CITY OF ALBUQUERQUE  
PLANNING DEPARTMENT  
June 21, 2006  
DRB Comments

PROJECT # 1004773

RE: Lots 12,13,20,21, Tract A, Block 18, N.A.A. Unit 1/sps,spbp

PROPOSED CONDITIONS
SCALE: 1"=40'

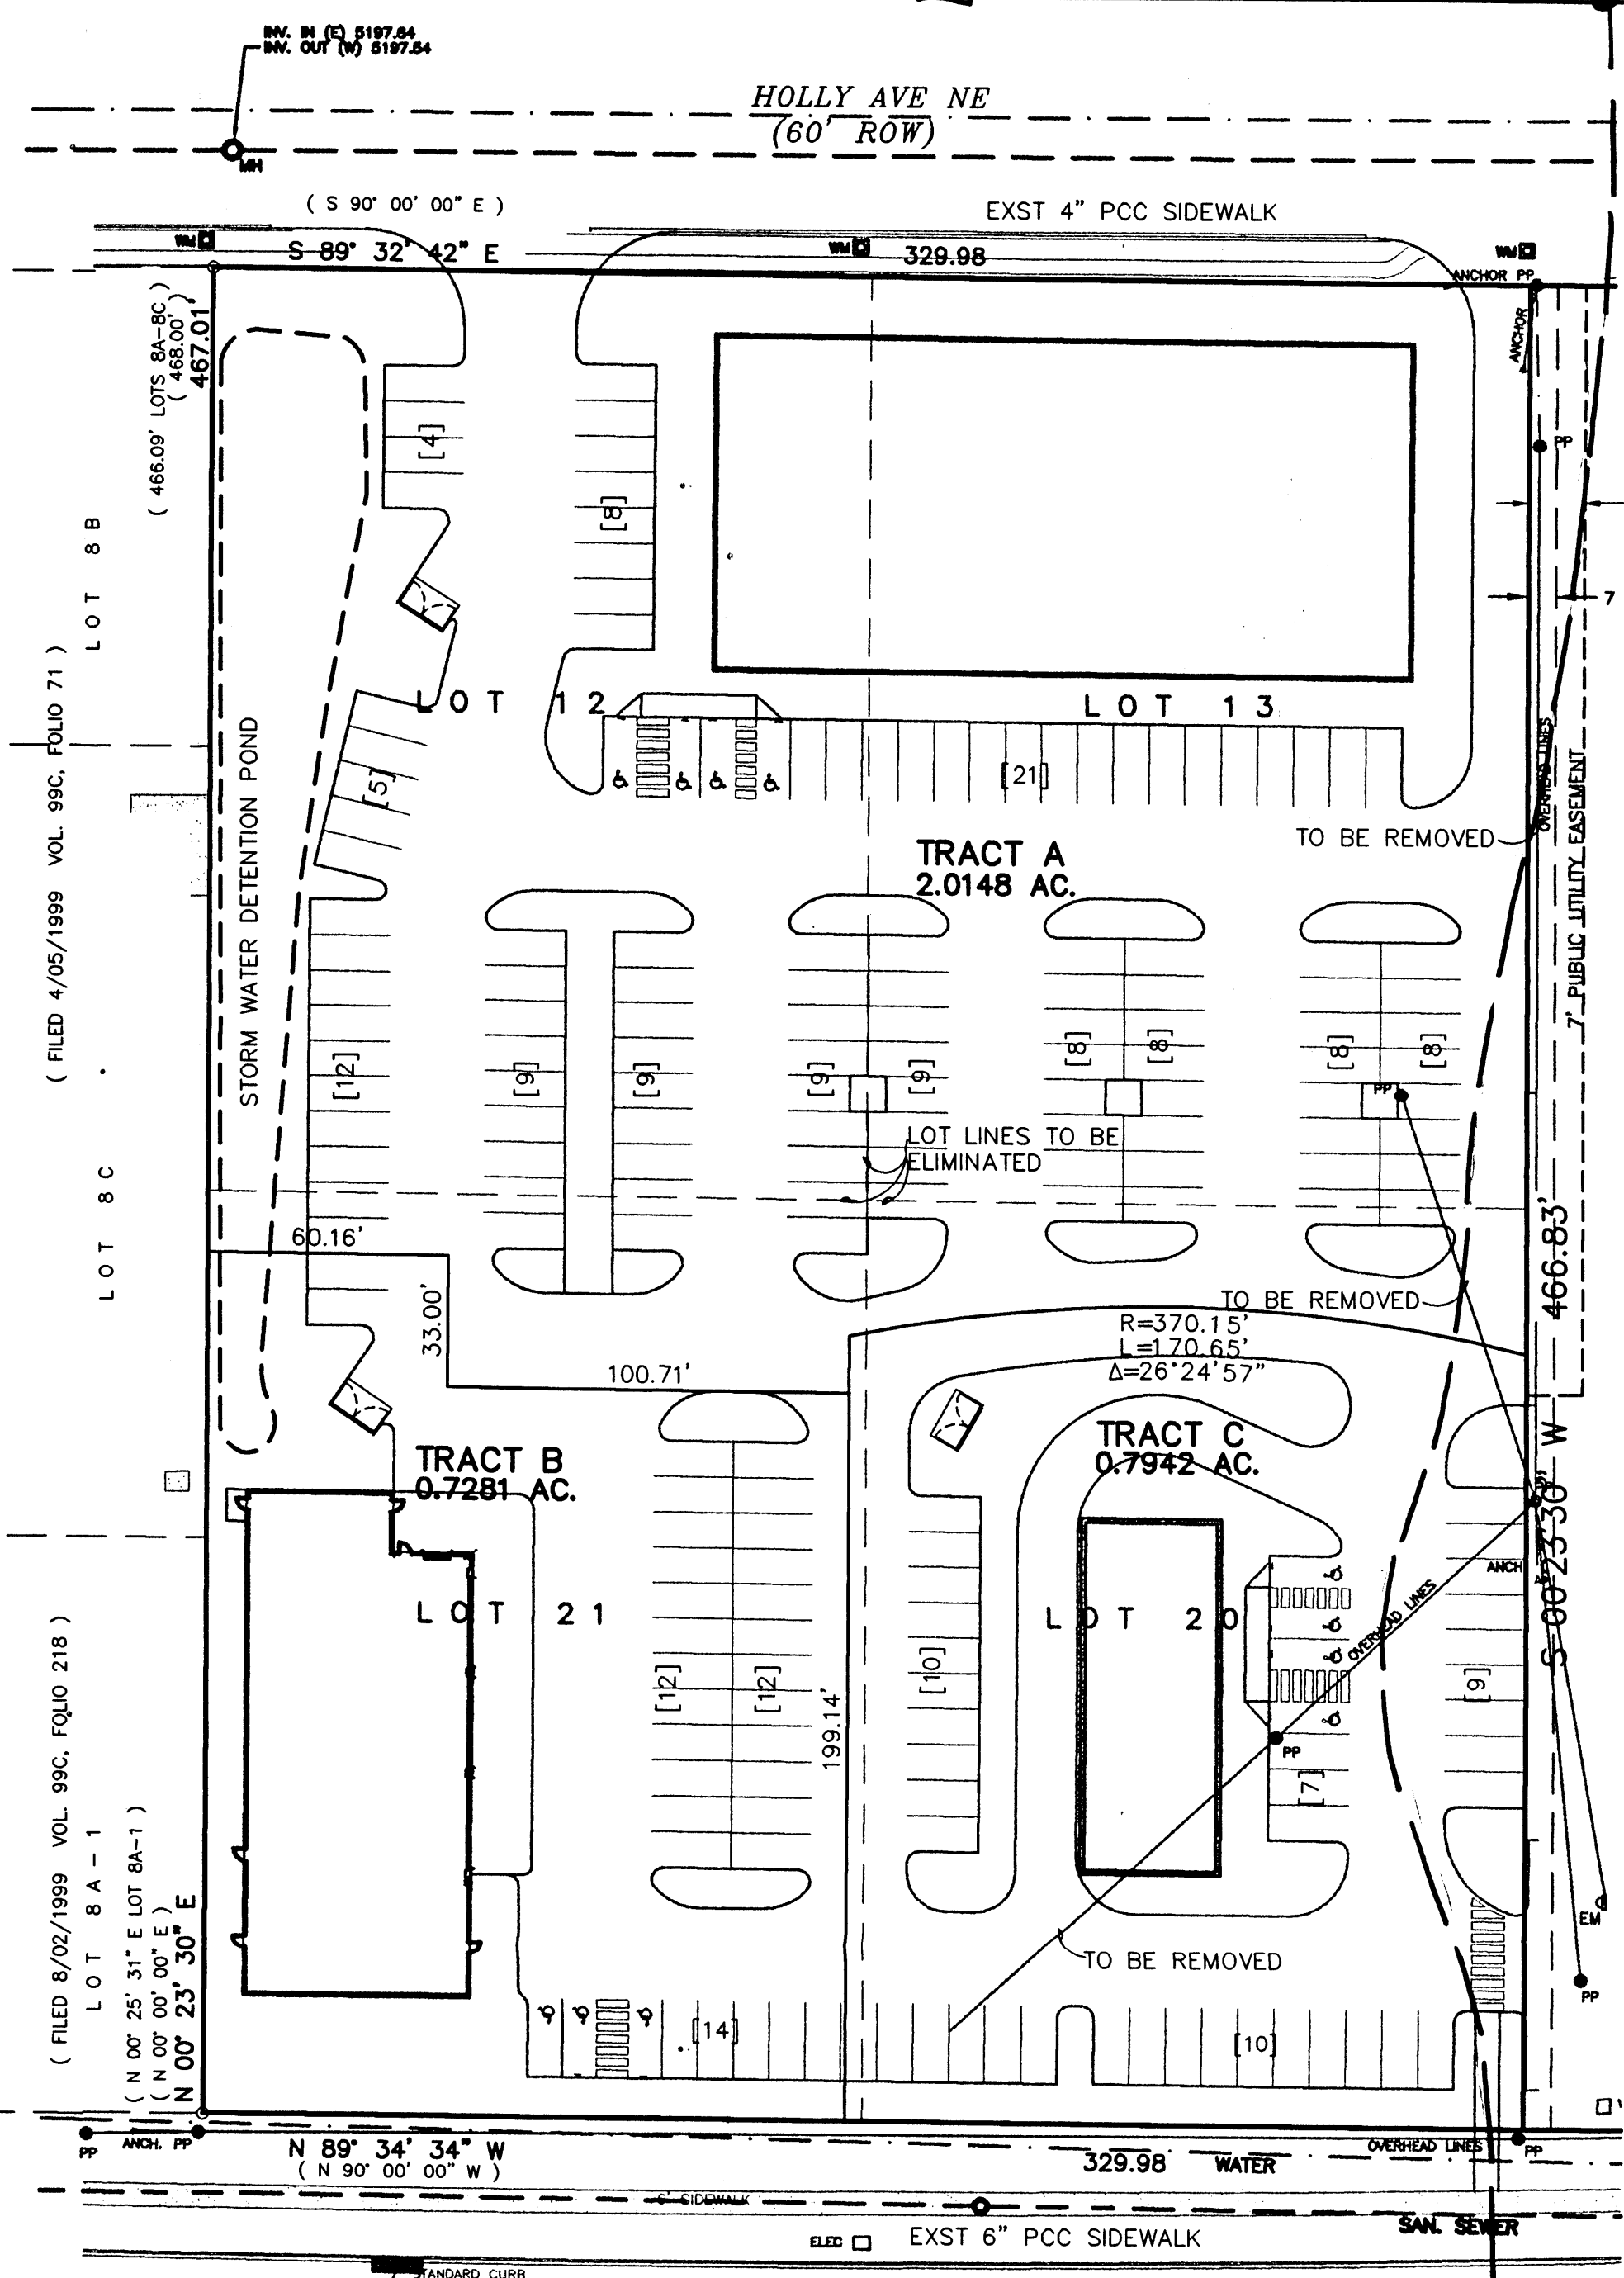
✓ The lot lines being eliminated should appear labeled as such on the SPS along with clearly defined new lot lines. The new lot lines on both site plans should be darkened for easy identification.

PROJECT TITLE
PASEO PLACE
 PASEO, N.E.
 ALBUQUERQUE, NEW MEXICO
 PROJECT MANAGER
 STEPHEN DUNBAR
 JOB NO.
 SHEET TITLE
SITE PLAN FOR BUILDING PERMIT

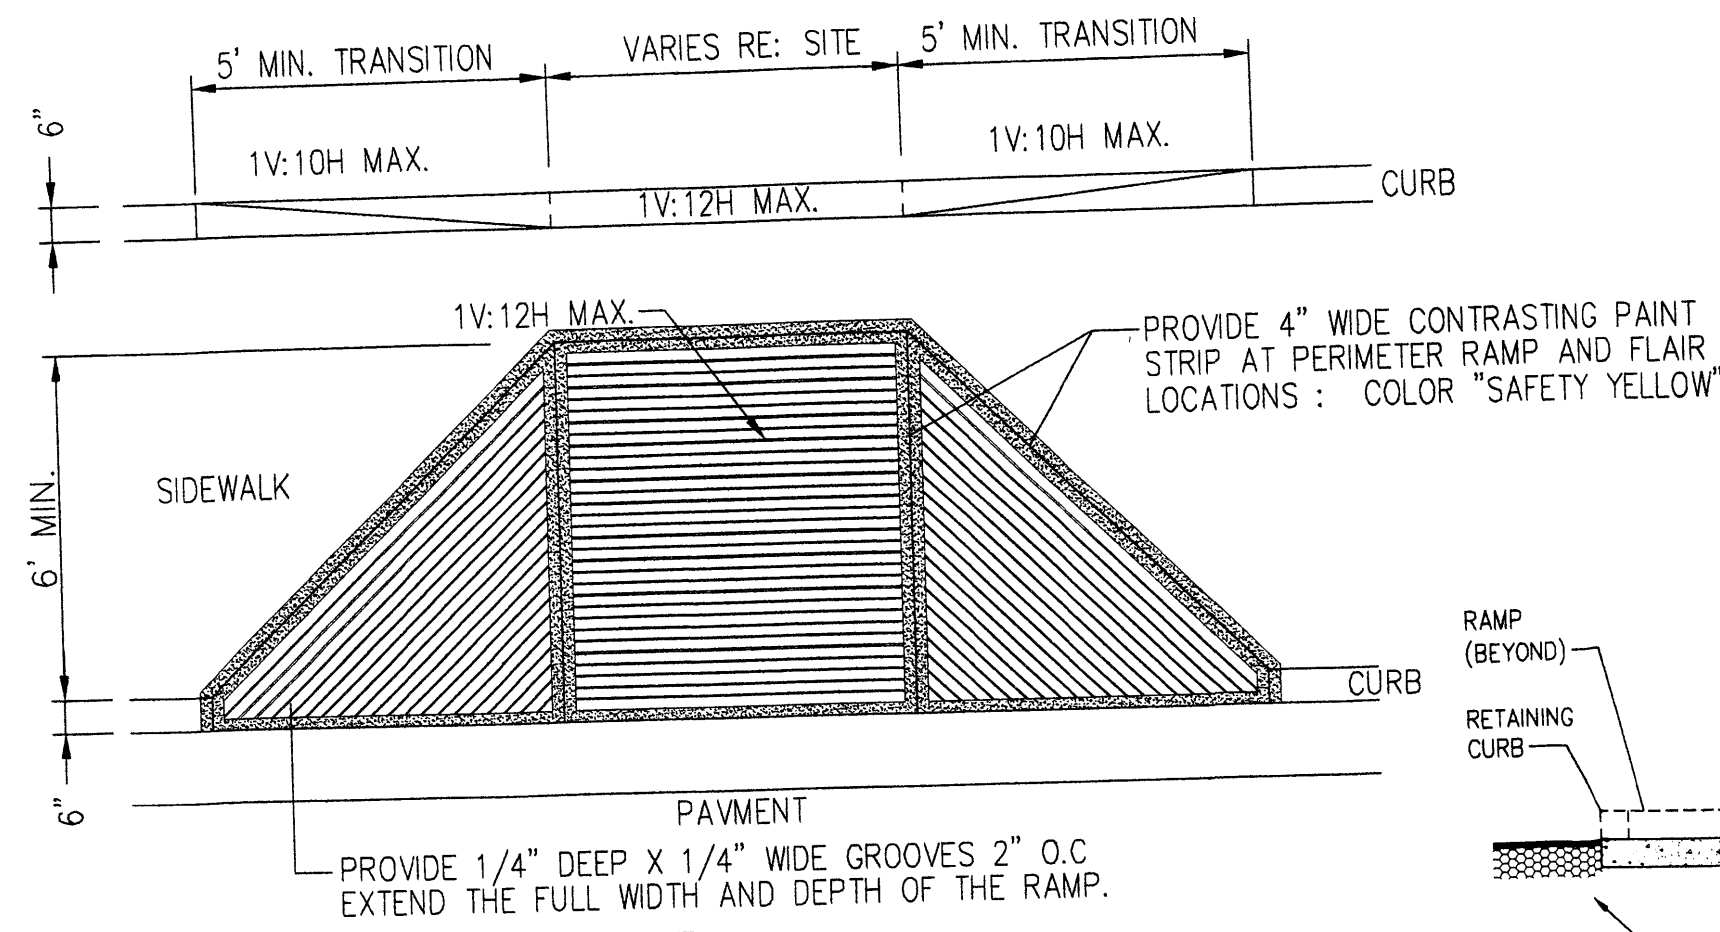
✓ The signature blocks: Remove the word "signoff" from the title. This word is used only to indicate final sign off after EPC approval. EPC was not involved in this site plan submittal.

✓ What is the trailer shown on the site plan? Why is there a black bar extending to the middle of Holly on the south side of the south access to the property? Does the concrete pad encroach on the property line?

- ✓ Are there any walls...retaining or perimeter...planned along Holly or Paseo del Norte?

Phase 1 shows a very irregular lot size. The required parking must be adjacent to the building for Phase I. What other reason is there for remote parking spaces as shown?
